Response to Submissions Report

State Significant Development – SSD 18_9095

Armidale High School Redevelopment

Butler Street, Armidale

Drawing Title
SITE CIRCULATION, VEHICLE &
PEDESTRIAN PLAN

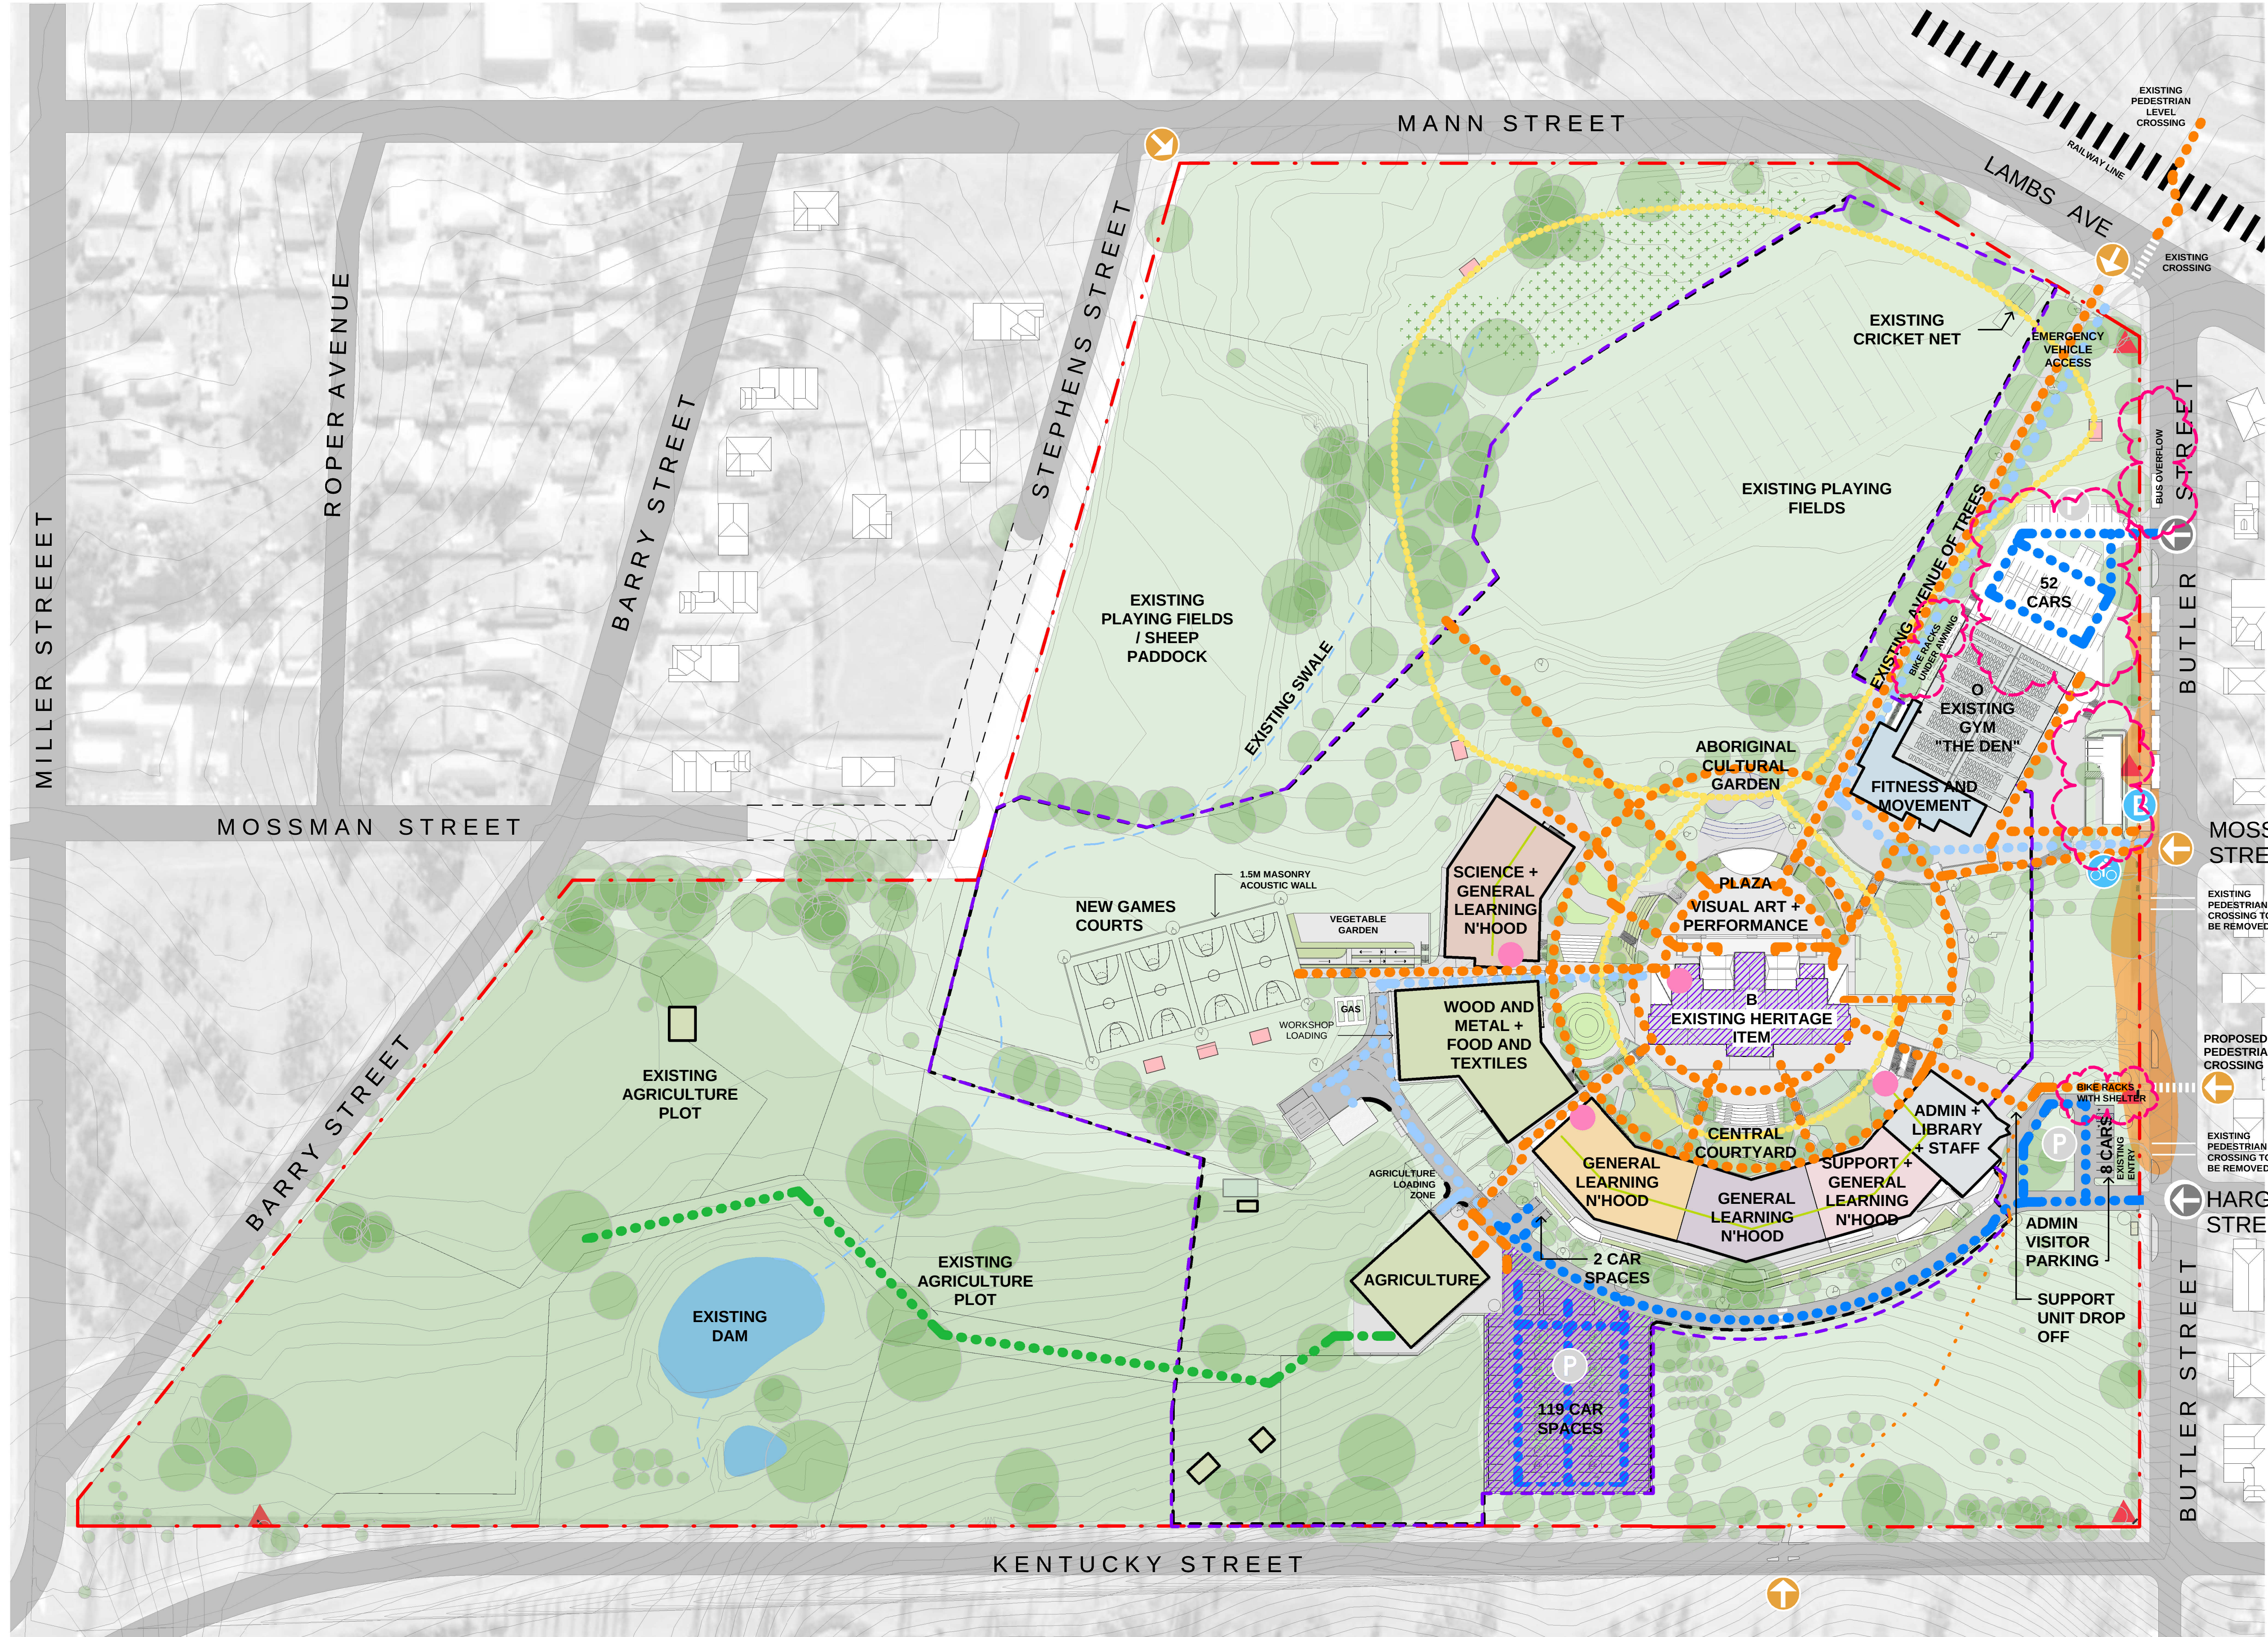
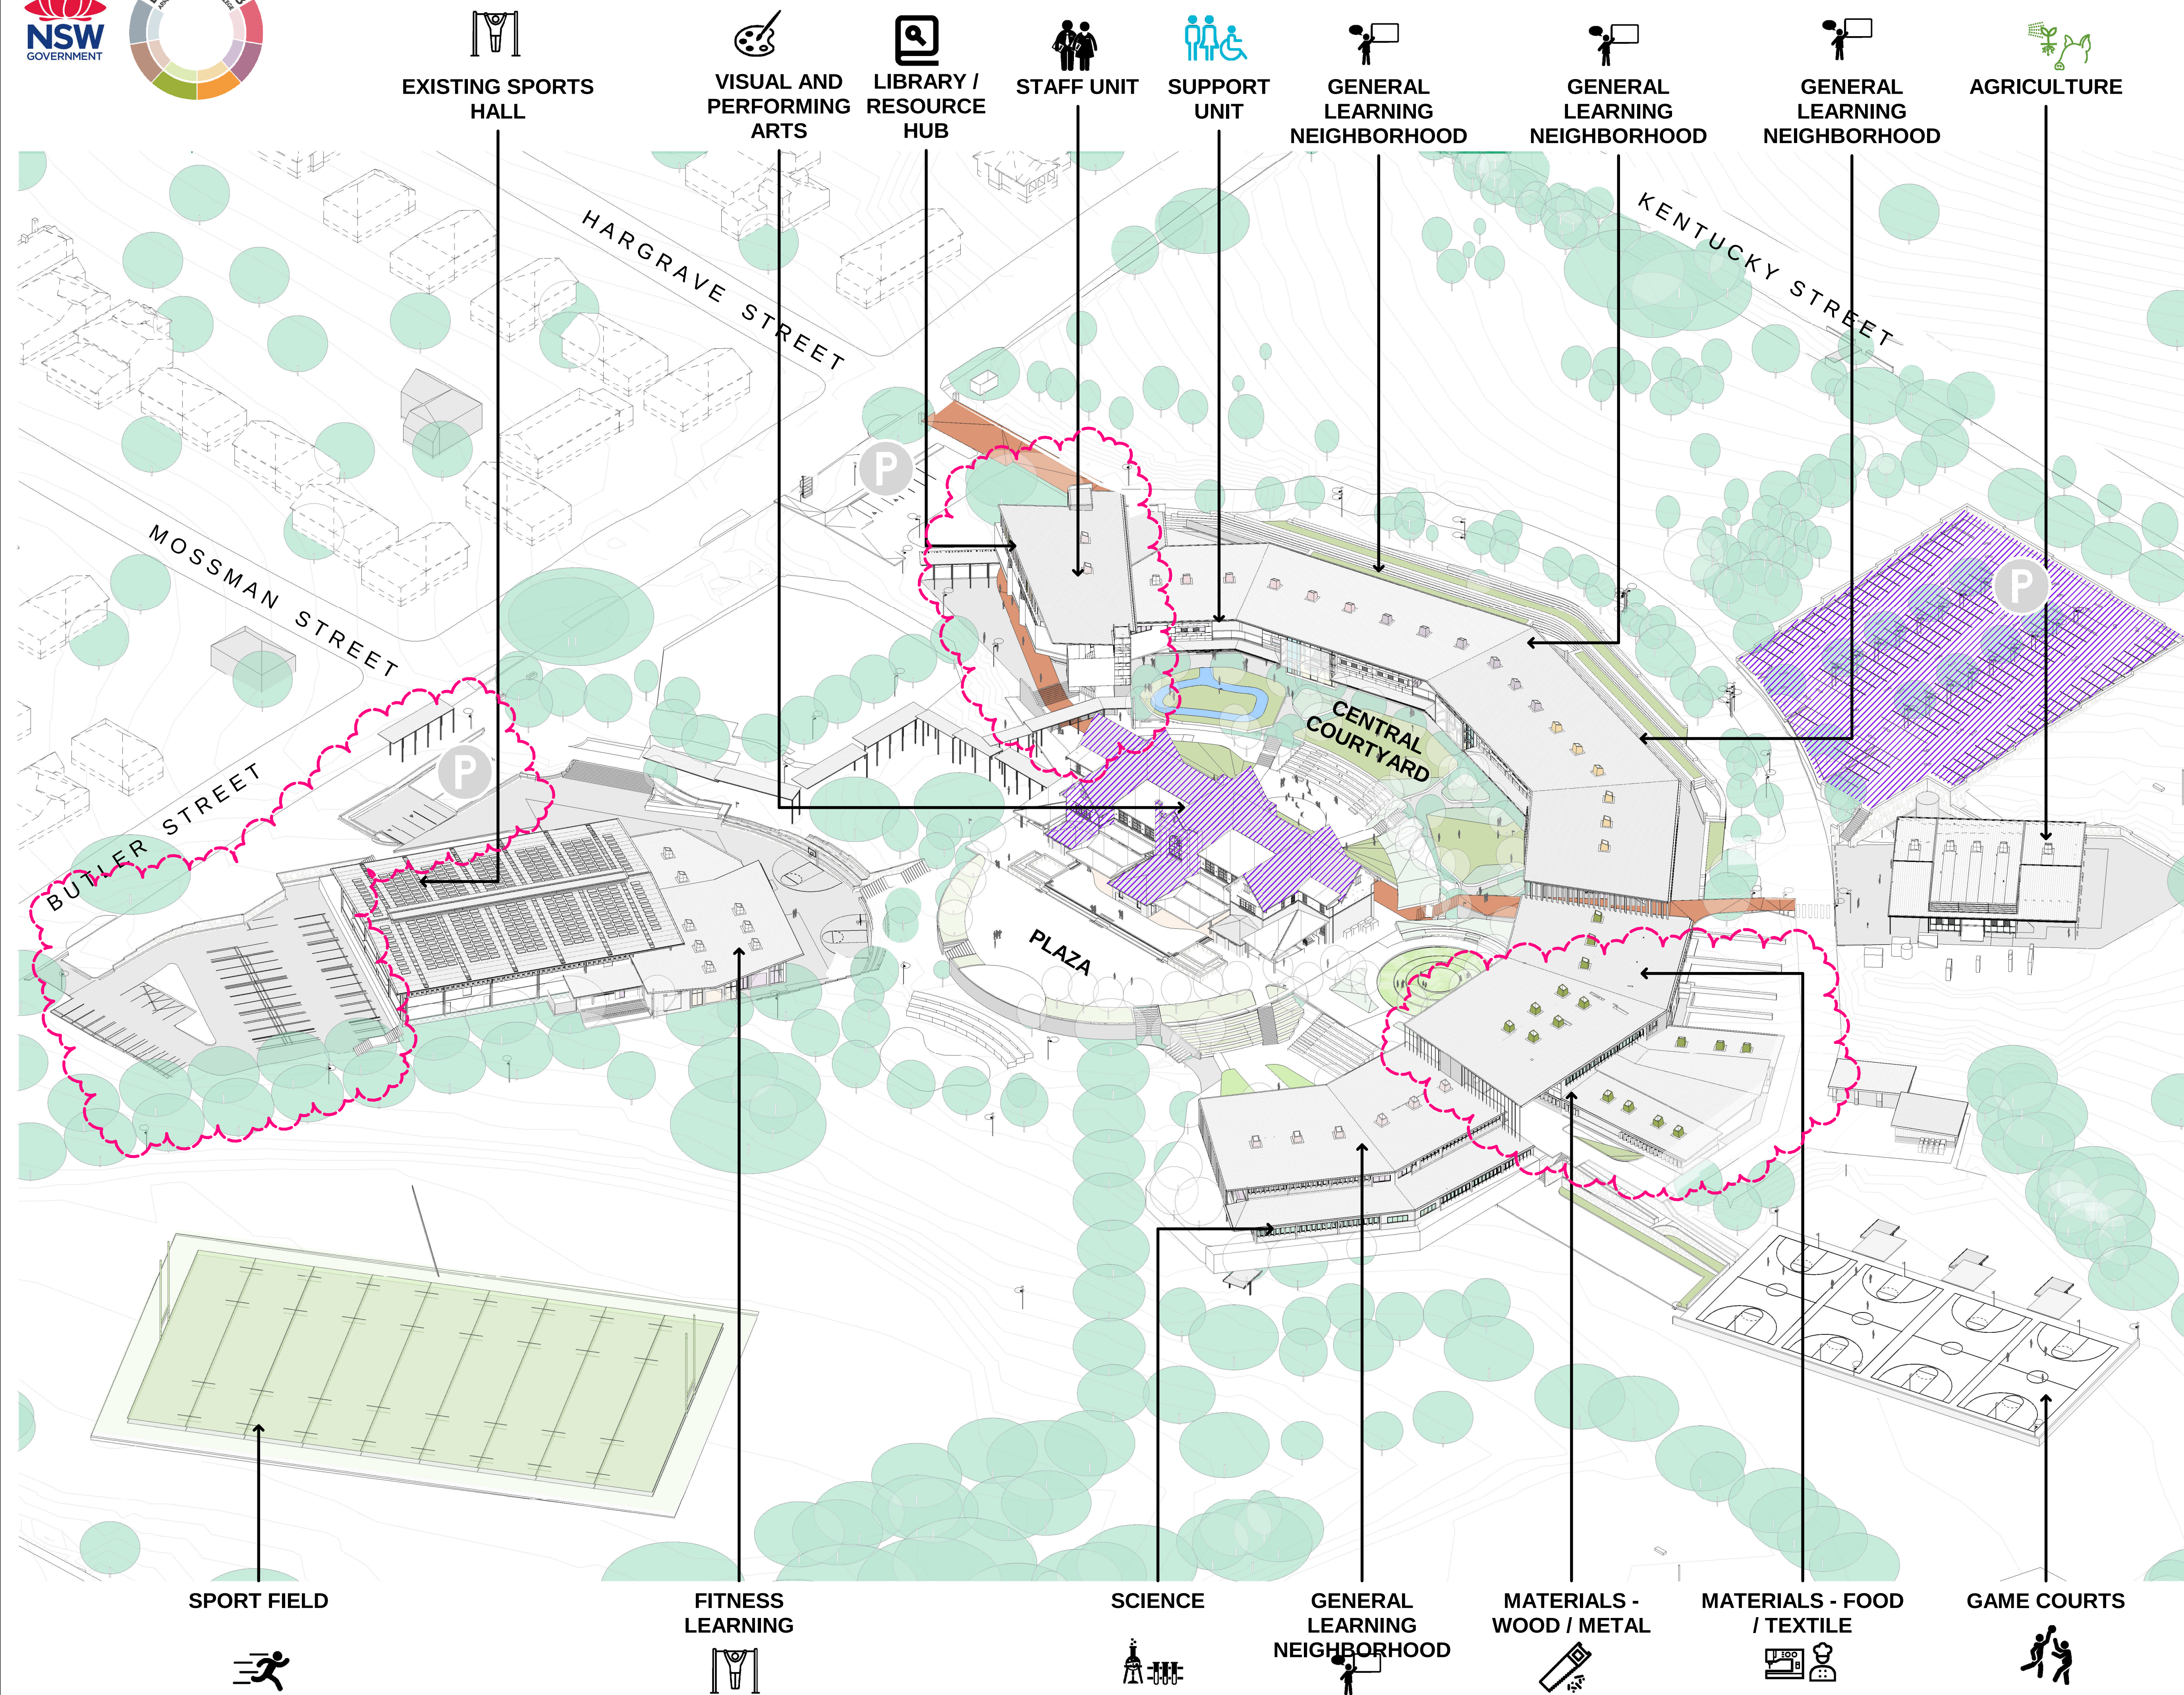
2. The proposal is a traffic generating development and should therefore provide adequate on-site parking, and not rely on parking availability on the surrounding road network. It is noted that Council has raised concerns with regard to the parking assessment, particularly in relation to the provision of parking for Year 11 and Year 12 students, and the inconsistency between the Environmental Impact Statement (EIS) and the TIA. Additional information is required addressing the inconsistencies between the EIS and the TIA, and the provision of adequate on-site parking for traffic that would be generated by the proposal.	SINSW understands the need for adequate on-site parking to minimise the impact on the local traffic network. Under the original proposal, three (3) parking areas provided a total of 164 parking spaces. Following review of opportunities for parking on the site, additional parking will be provided adjacent to the existing gymnasium (Den), increasing the parking there from 35 spaces to 56 spaces (being 21 additional spaces). Therefore, the site will provide a total of 185 car parking spaces, which is in excess of Council's DCP requirements. This revised car parking arrangement has been endorsed by Council. The inconsistencies between the EIS and TIS have been rectified through amendment of the TIA.	Architectural Plans Appendix 1 Traffic Impact Assessment Appendix 5
